SSD_7417: REGIMENT MIXED-USE REDEVELOPMENT, UNIVERSITY OF SYDNEY, DARLINGTON CAMPUS

UNIVERSITY OF SYDNEY RESPONSE TO SUBMISSIONS

18 MAY 2017

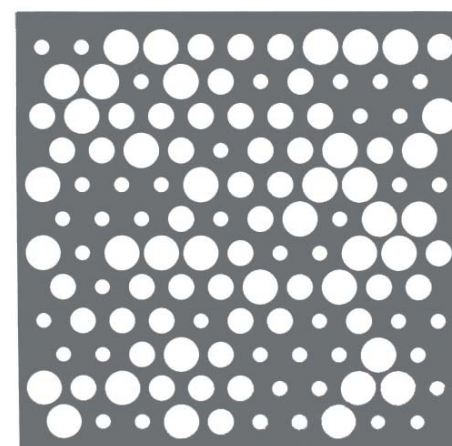
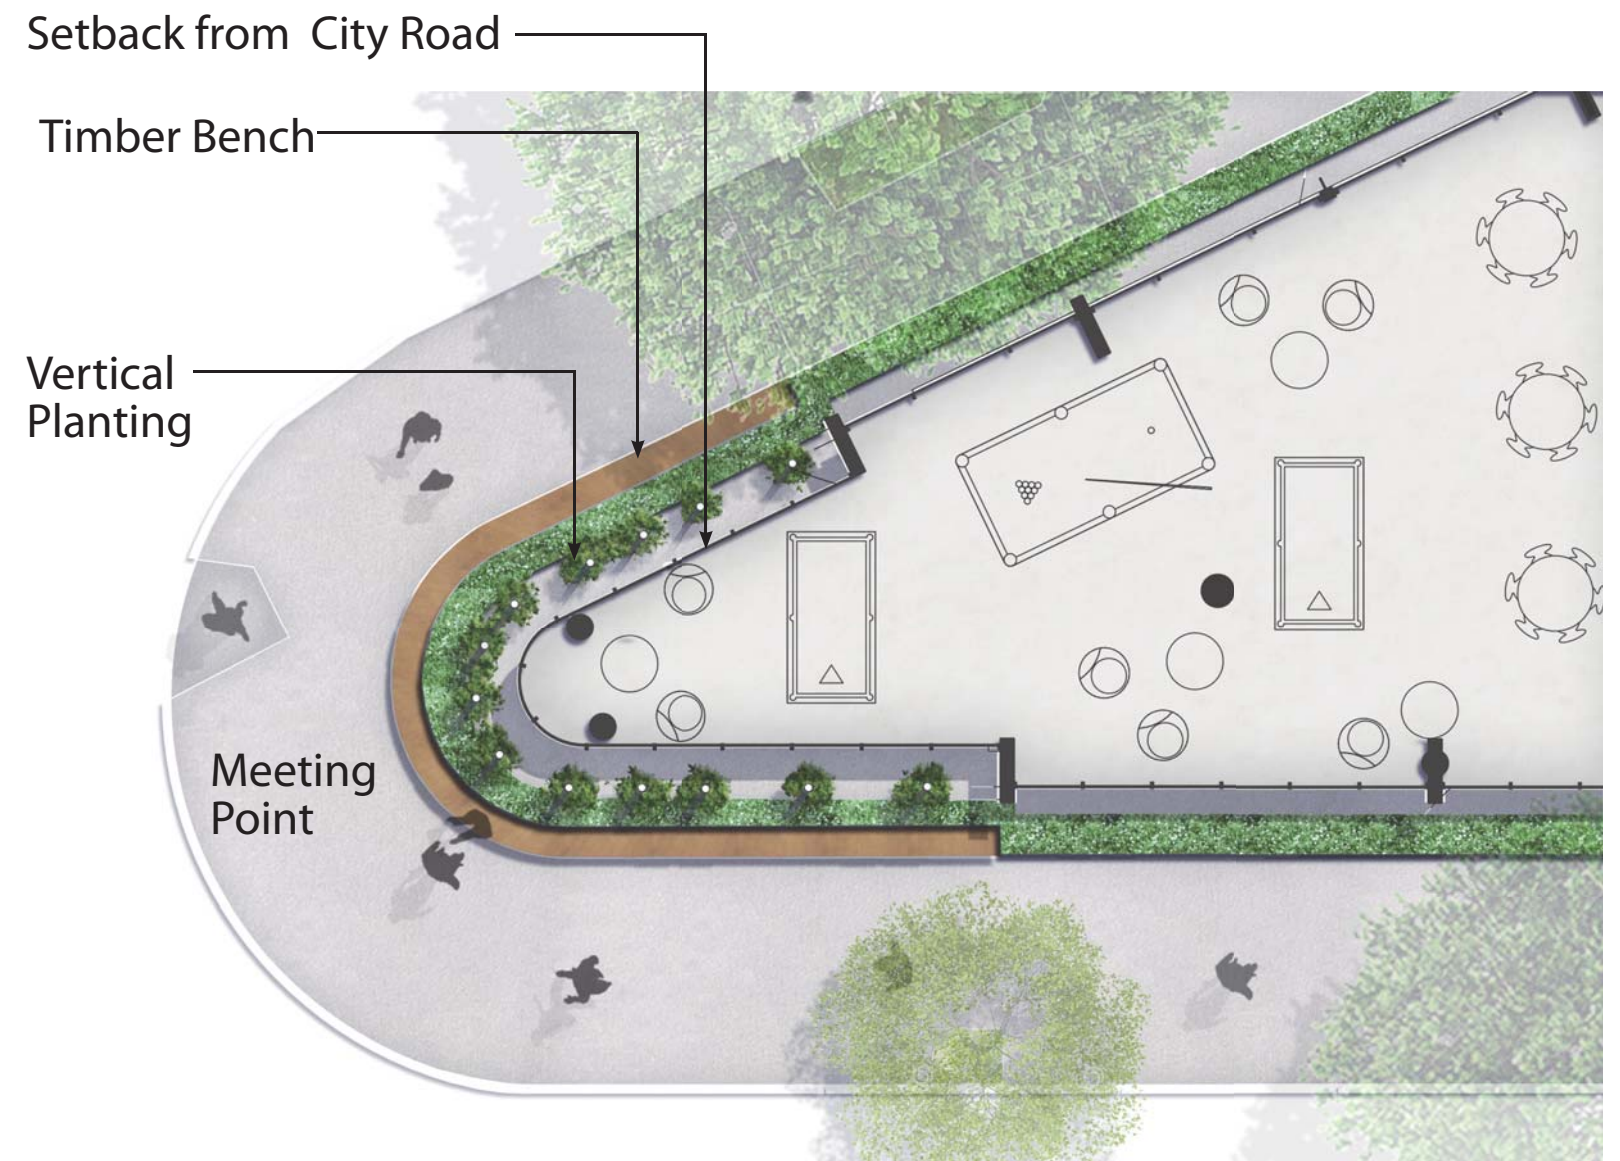
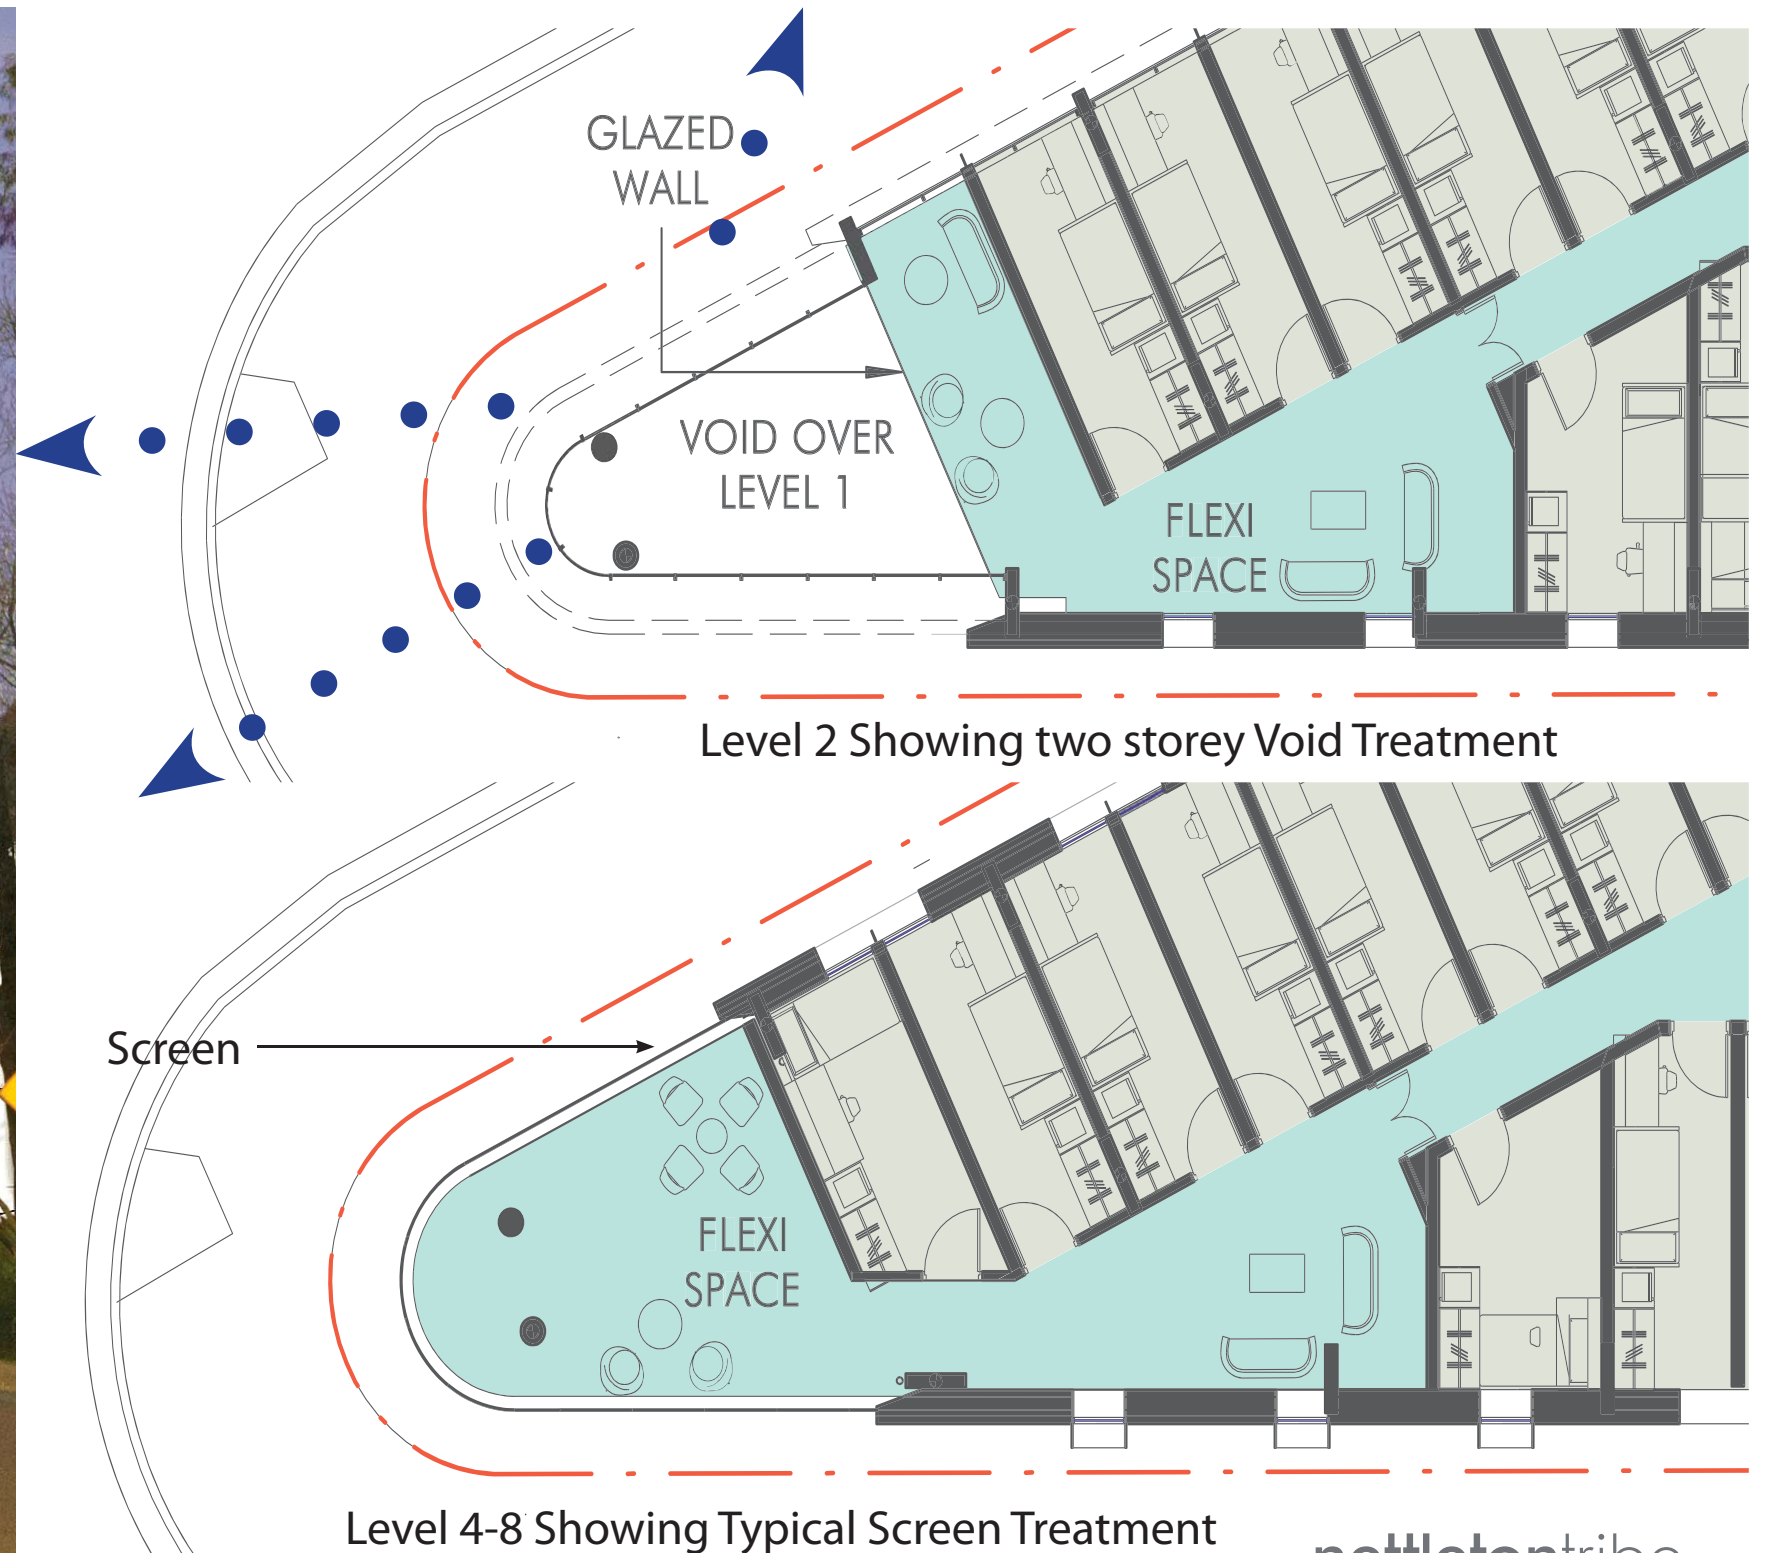
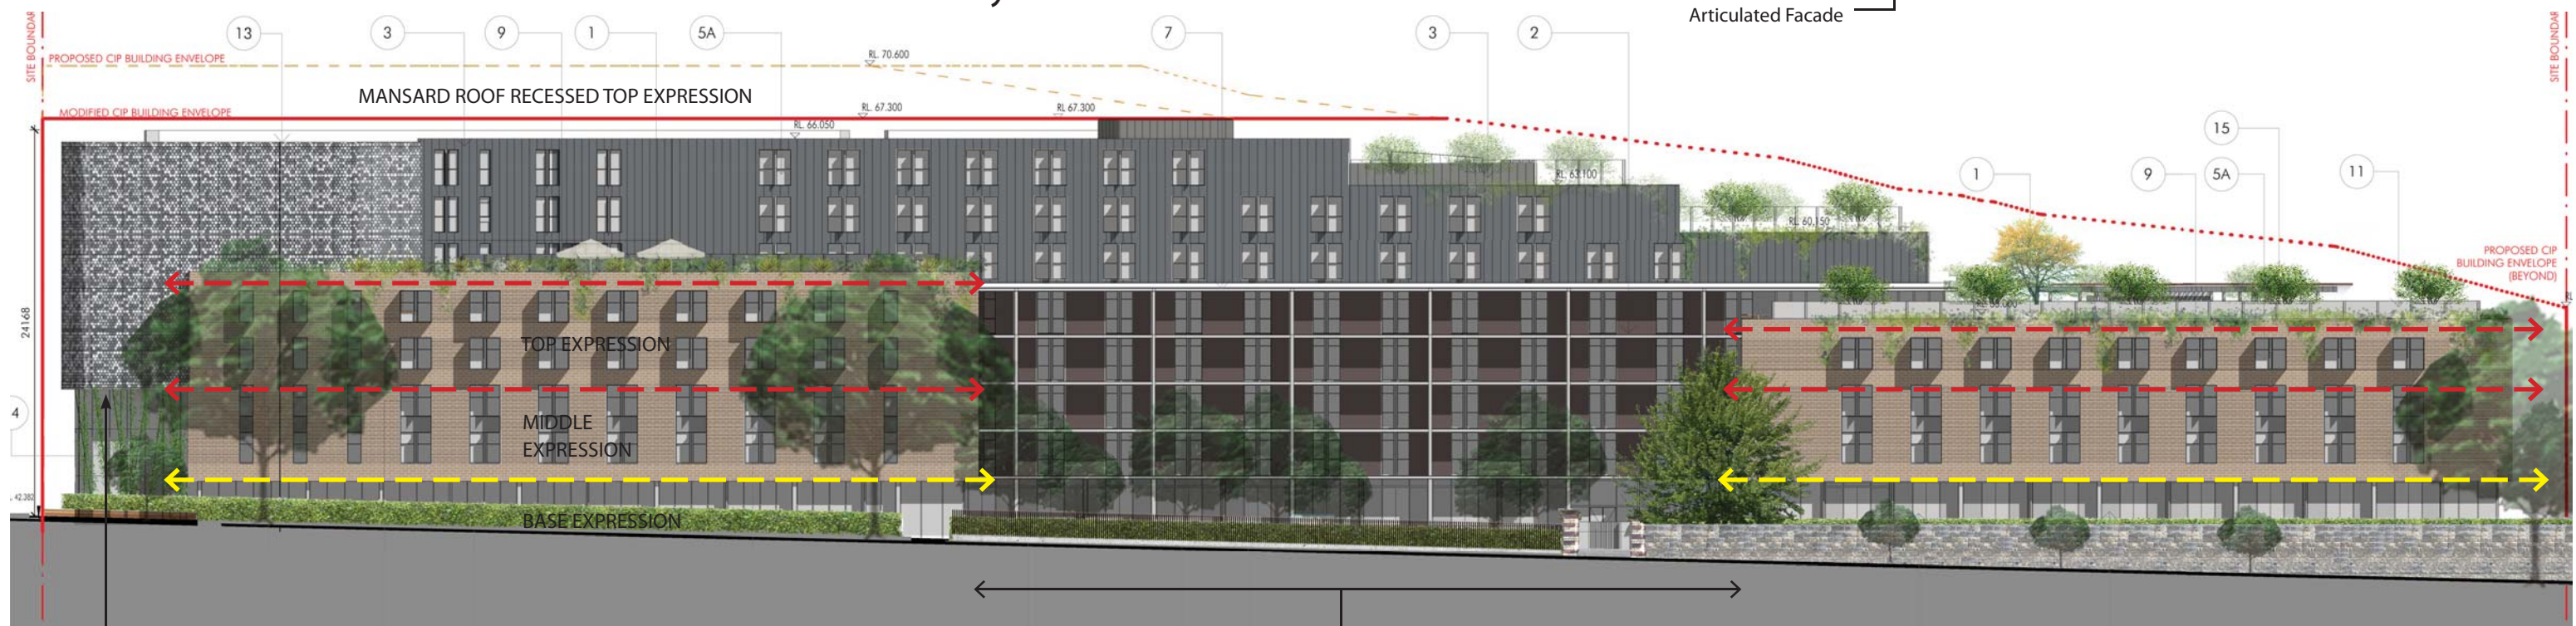
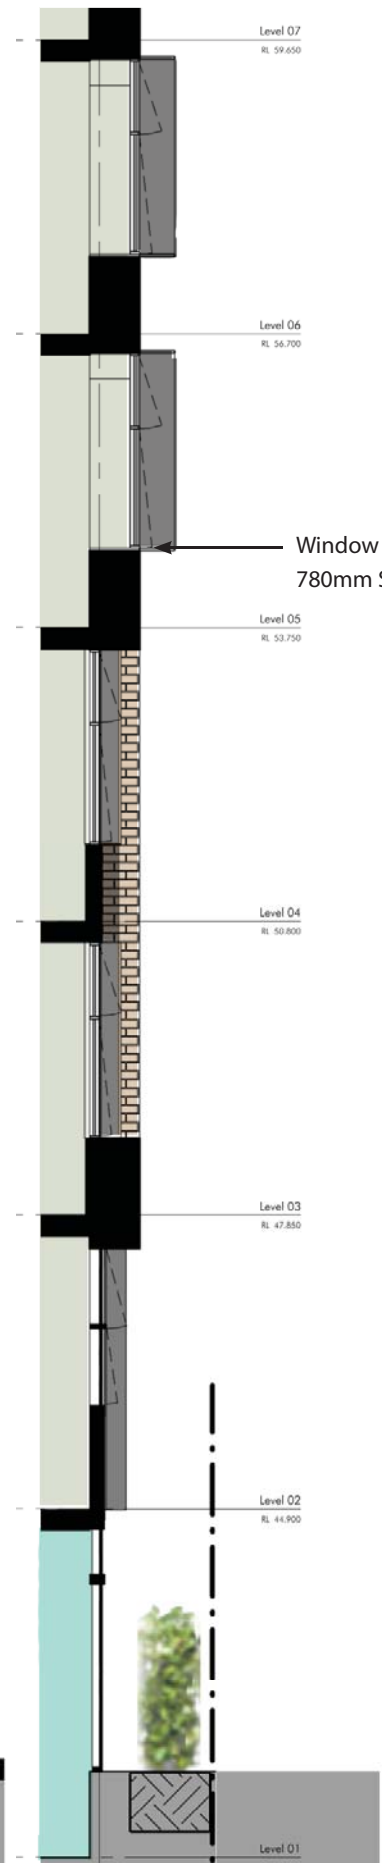
2. Integrated mixed use approach with the inclusion of campus-wide facilities within the building is supported	Noted
3. The sharp corner of the site at the intersection of Darlington Road and City Road represents a significant architectural opportunity and key visual place marker for the University. The current proposed form and building facade composition do little to celebrate this key contextual opportunity and are not supported.	Noted Please refer to the University's response under DPE Issue No.1 on page 3 of this document for a response to these queries.

4. Whilst the selection of masonry as the primary facade material is supported, the potential of brick both formally and decoratively is not fully exploited in the current design of the facades. Given the civic prominence of the building a considered and integrated approach to the form, mass and articulation of the brick is recommended.	Noted Please refer to the University's response under DPE Issue No.1 on page 3 of this document for a response to these queries.

SSD 7417 – REGIMENT MIXED-USE REDEVELOPMENT	
DPE ISSUE	USYD PROJECT RESPONSE
	<p>OPTION 2B</p> <p>With the introduction of a light weight decorative screen wrapping around a curved glazed flat iron corner, opportunity's open up for improvement as follows:</p> <ul style="list-style-type: none"> - The screen acts as a contemporary gateway to the University precinct, reflecting and responding to the University Indigenous Wingara Mura design principles. - As the screen turns the corner it sleeves the two brick facades on City and Darlington Road, managing the transition in scale. - The screen acts as solar protection from the western sun. - The screen filters light from the social spaces within the building, presenting as a delicate beacon and a unique place marker and identifier. - At the ground and first floor, the screen stops to reveal an active and transparent 'shop front' to the student spaces. The building has been pulled back to respect and remember the garden which has been removed. The green edge continues from the pocket park opposite. Bench seating may create a meeting and resting point in the shade, along the expansive City Road. - The green vertical elements, soften and enhance the hard urban edge, and humanise the corner. - The first floor slab has been removed at the corner to create a two story space, with a highly active student space within. - The veiled screen continues along the high level frontage to Darlington Street, improving privacy to the upper level spaces. The brick screen to the lower levels is also extended to reduce the glazed area, and create more unity between the two street facades.
